Stonestreet Green Solar

Statement of Common Ground with the Environment Agency

PINS Ref: EN010135

Doc Ref. 8.3.2(A)

2.7(A) Illustrative Landscape Drawings

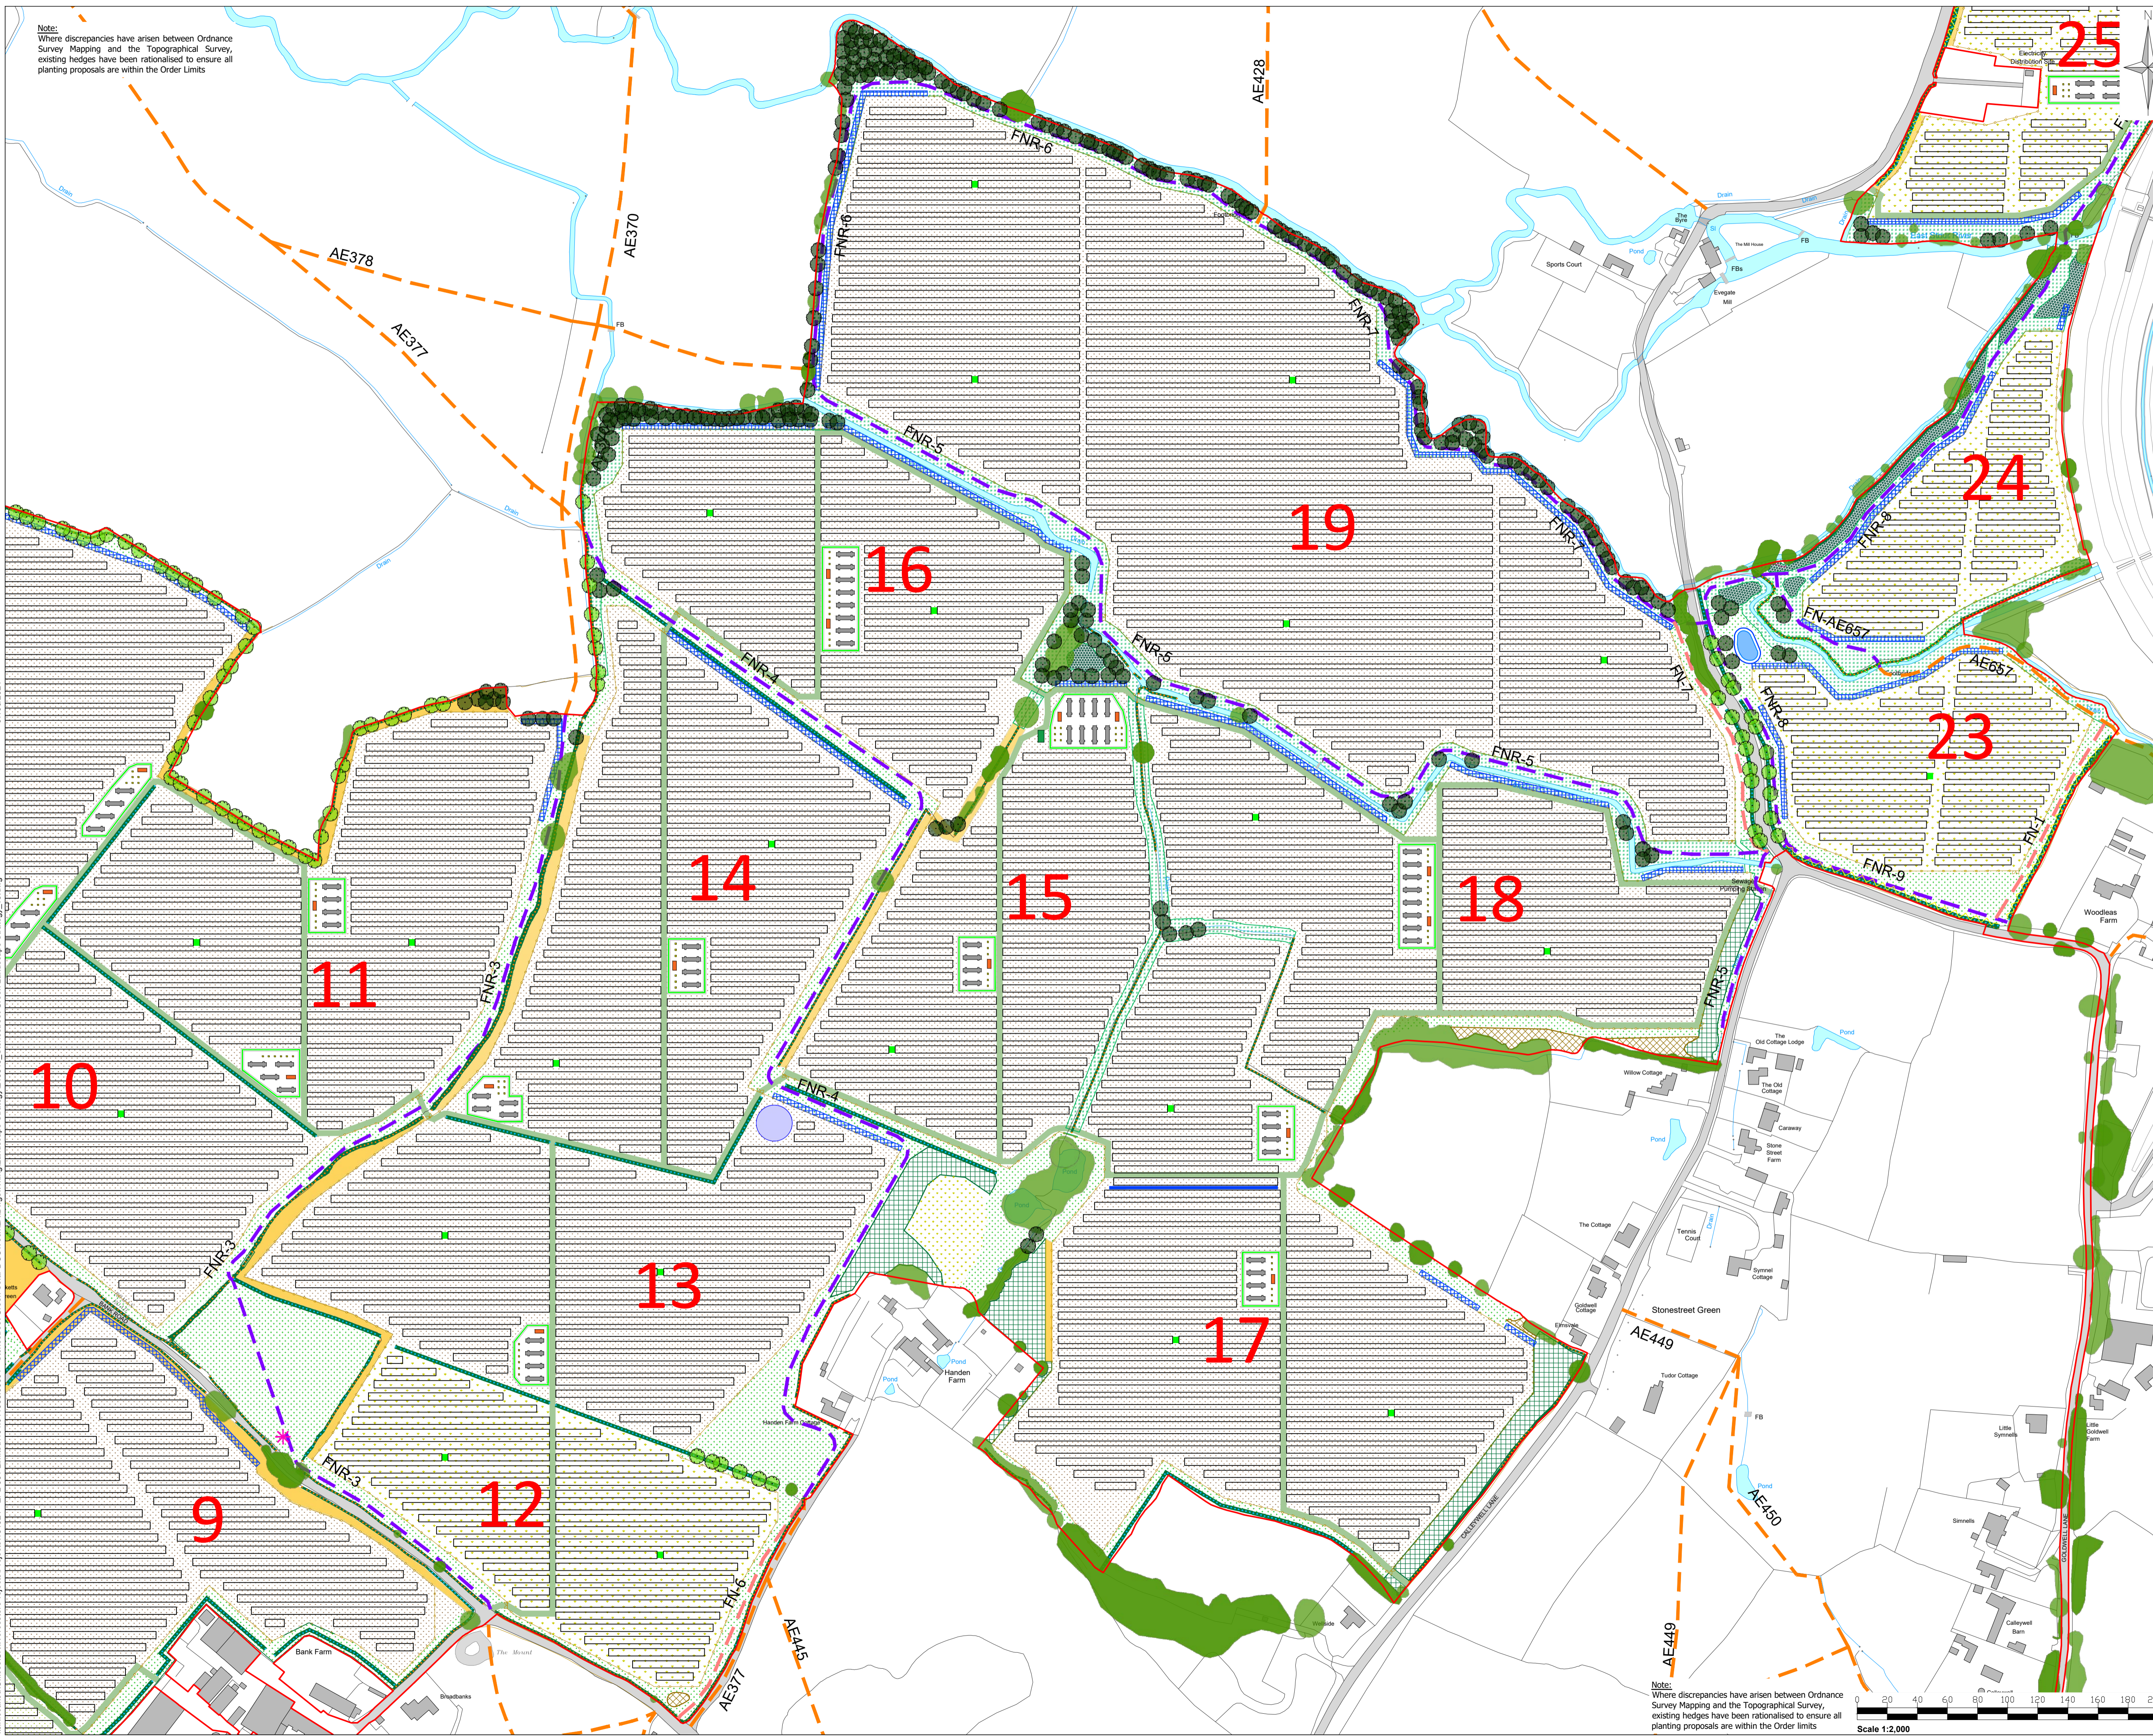
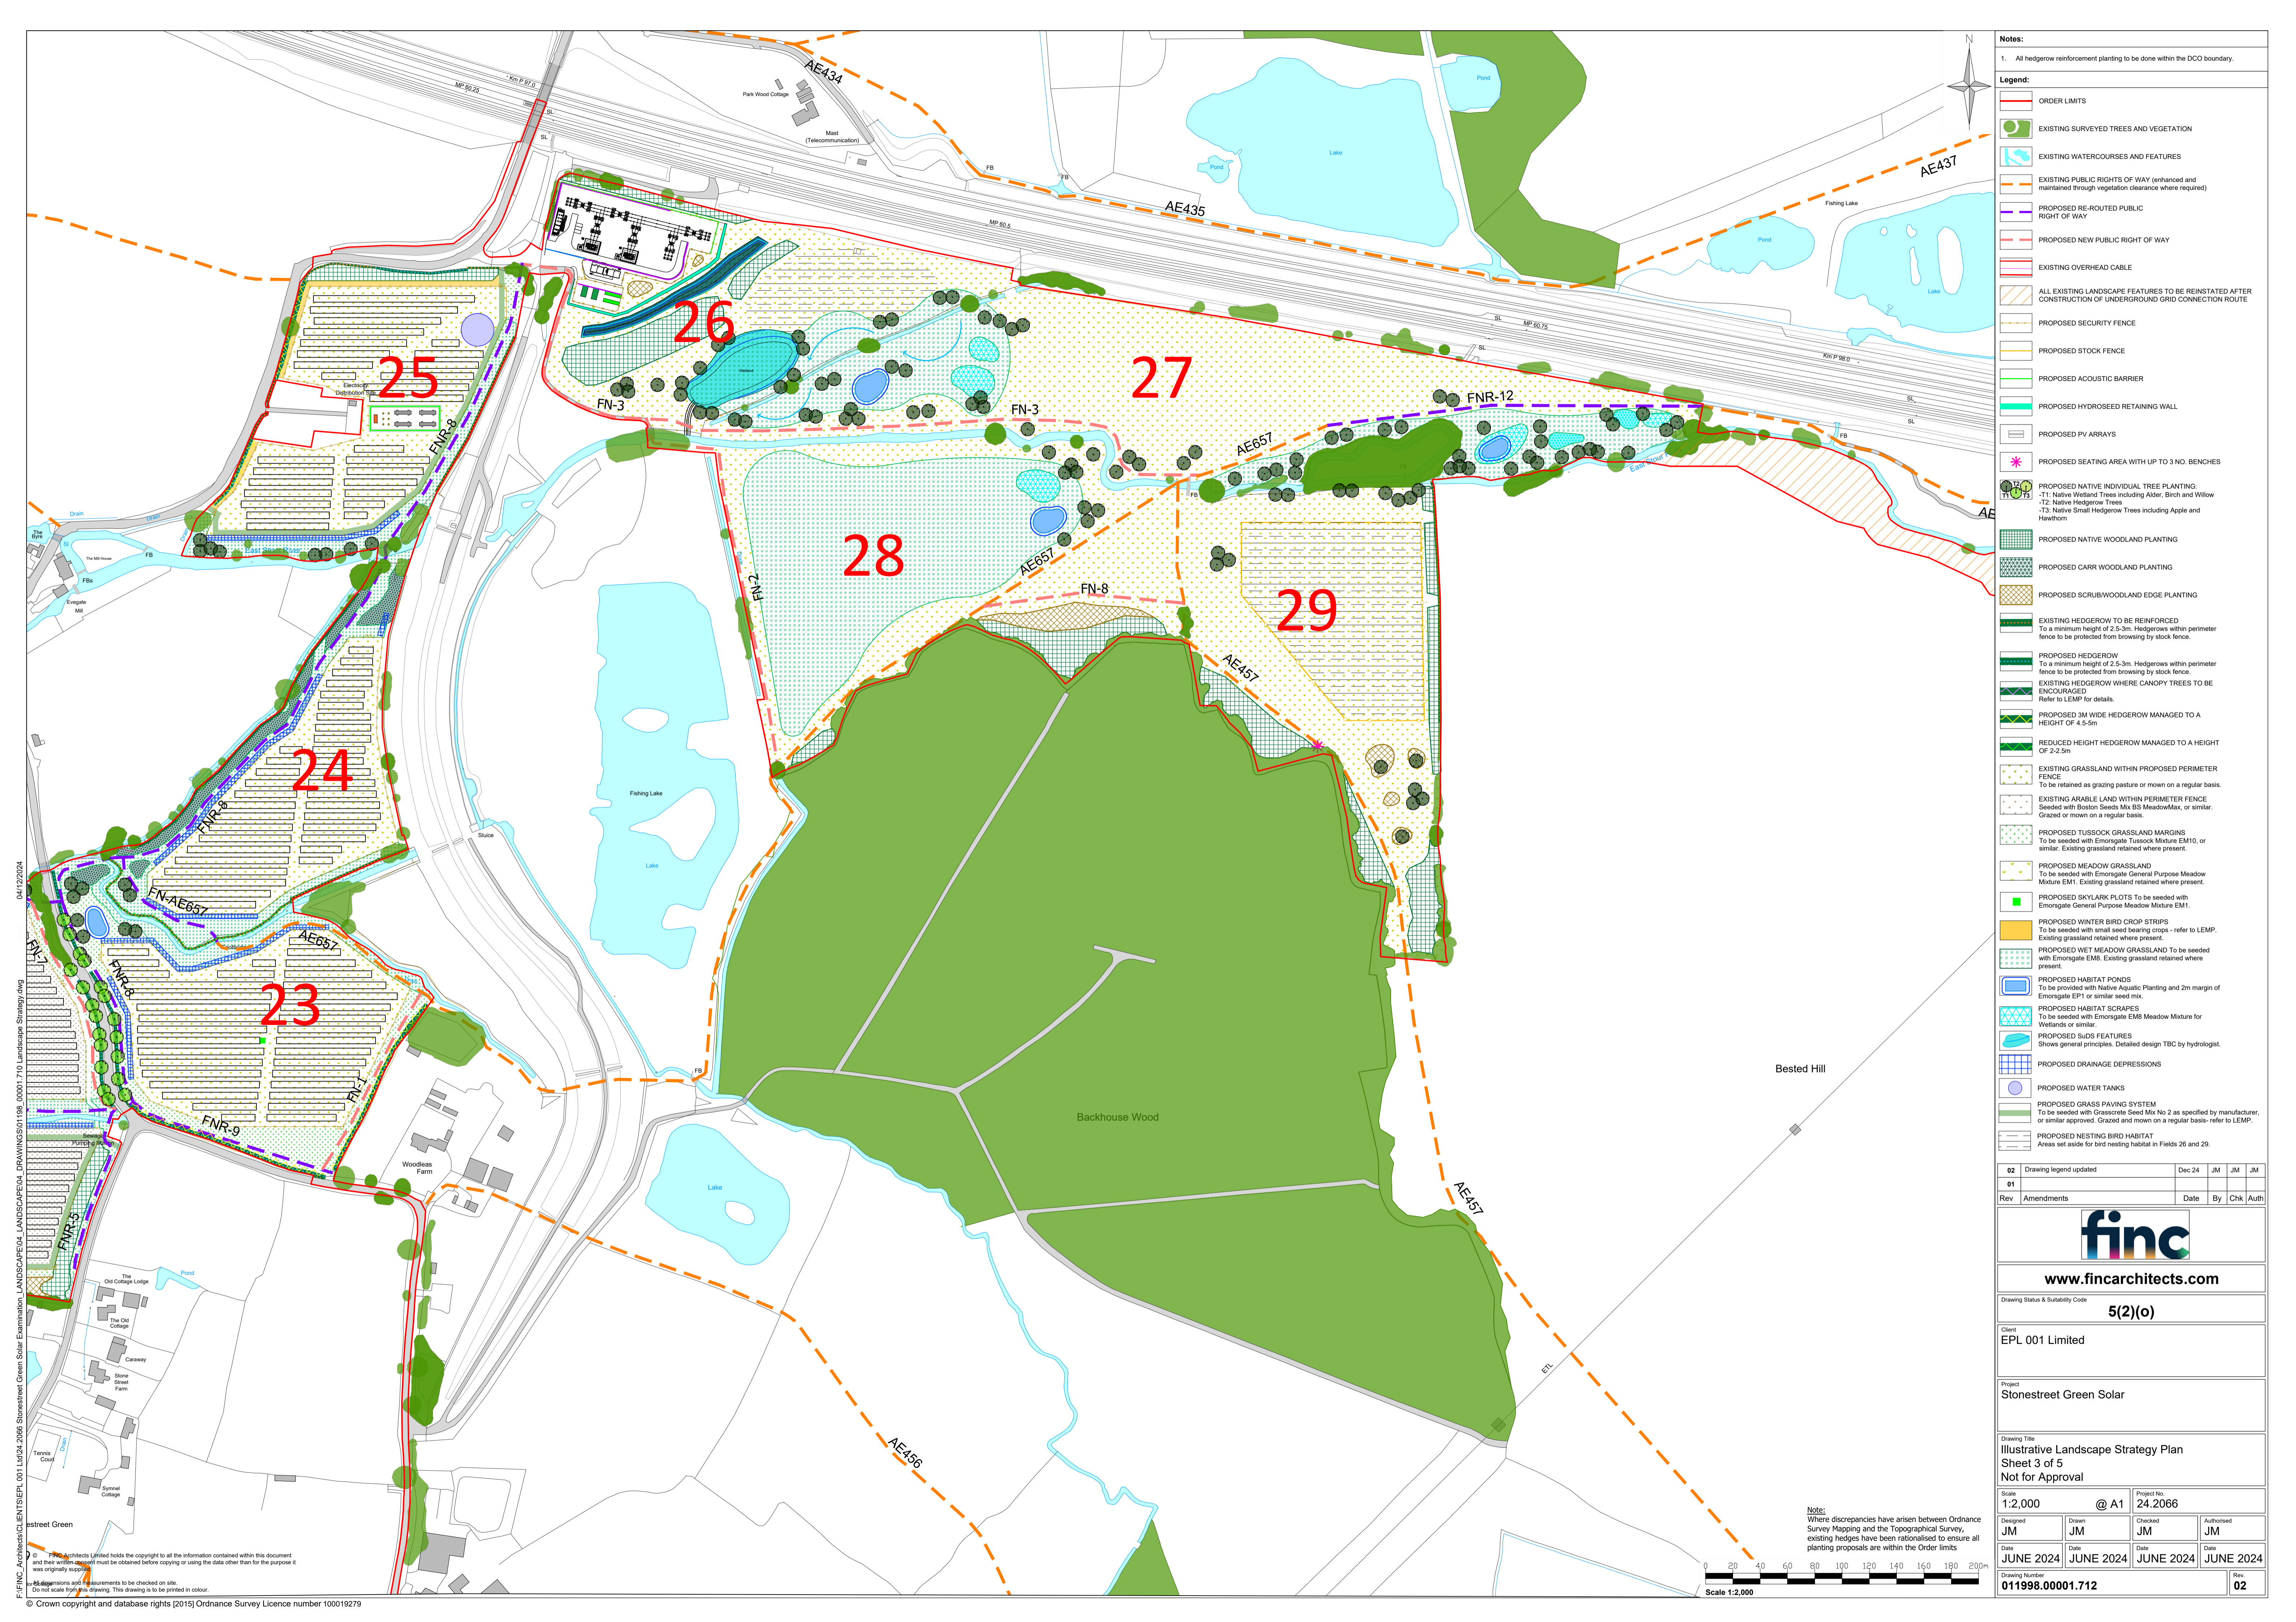
2.10 to 12	RR	Issue 3 - Flood Storage Calculations	<p>Situation: The 'Floodplain Compensation level for Level Calculation' table from 'Annex D: Floodplain Compensation Level for Level Calculations' of the FRA demonstrates a net increase (1,543.11 m3) in flood storage downstream of the Aldington Flood Storage Area but does not show any net increase within Aldington Flood Storage Area as referenced in the Outline Operational Surface Water Drainage Strategy (OOSWDS). Paragraph 5.1.5 of the OOSWDS states "The swale and wetland areas have both been designed to enhance biodiversity and ensure that there is no adverse impact on water quality. In addition, the wetland area, which will be sited within the AFSA, will increase the capacity of fluvial flood storage available. This will therefore contribute to a small reduction in downstream flood risk." (<i>APP-094 – Doc 5.4 Environmental Assessment</i>)</p>	<p>None of the works proposed within the AFSA involve any build up in ground levels.</p> <p>The works proposed relate to;</p> <ol style="list-style-type: none"> 1. Superficial treatments and vegetation management with a commitment made that vegetation management will be ongoing with any accumulated material removed from the AFSA. Such work would therefore have a neutral impact on flood storage, 2. The provision of fencing around the skylark area in Field 29 as illustrated on the Illustrative Landscape Drawings (Doc Ref. 2.7(A)) [REP1-005] (Sheet 3 of 5 - drawing number 011998.00001.712). The fence posts would result in a negligible loss of flood storage, but at a level that would be difficult to quantify. 3. The creation of ecological scrapes and ponds as illustrated on the 	Under discussion

2.13	RR	Issue 3 - Flood Storage Calculations	<p>Solution: The applicant should also confirm that there is no loss of flood storage capacity in Aldington Flood Storage Area from the landscaping works including but limited to the woodland planting, tree planning, habitat scrapes and habitat ponds.</p> <p>22/11/2024 (EA) No further comments, our above comments for Issue 2.10 to 12 apply.</p>	As above	Under discussion

Ref	Relevant Application Document	Description of Matter	EA Current Position	Applicant's Current Position	Status
			<p><i>Appendix 10.2: Flood Risk Assessment; APP-159 – Doc 7.14 Outline Operational Surface Water Drainage Strategy</i></p> <p>Impact: The storage capacity of Aldington Flood Storage Area may be reduced by the proposed landscaping works.</p> <p>Solution: The applicant should amend the flood storage calculations within the 'Floodplain Compensation level for Level Calculation' table from 'Annex D: Floodplain Compensation Level for Level Calculations' of the FRA to show the flood storage increase inside Aldington Flood Storage Area as stated in the paragraph 5.1.5 of the OOSWDS "increase the capacity of fluvial flood storage available".</p> <p>22/11/2024 (EA) As outlined above when the Outline OSWDS (Doc Ref. 7.14) is updated to include that there will be no net loss of storage capacity within the AFSA this will be conditioned. We have no further comments to make until we have reviewed the requested supporting calculations and updates to</p>	<p>Illustrative Landscape Drawings (Doc Ref. 2.7(A)) [REP1-005] (Sheet 3 of 5 - drawing number 011998.00001.712). These would be formed by excavation only with all spoil removed disposed of outside of the AFSA. As such these works would only increase the available flood storage volume.</p> <p>4. The creation of the wetland area which will receive storm runoff from the Project Substation. This will be formed by excavation and will not involve impounding water to a level above the existing ground surfaces. As such the formation of this feature can only increase the volume of flood storage available.</p> <p>The net effect of these works will clearly be an increase in the available flood storage volume within the AFSA. On this basis no further assessment was deemed necessary.</p> <p>In response to this comment work is however now being undertaken to quantify the changes resulting from items 2, 3 and 4 above. This additional detail will be included within ES Appendix 10.2: Flood Risk</p>
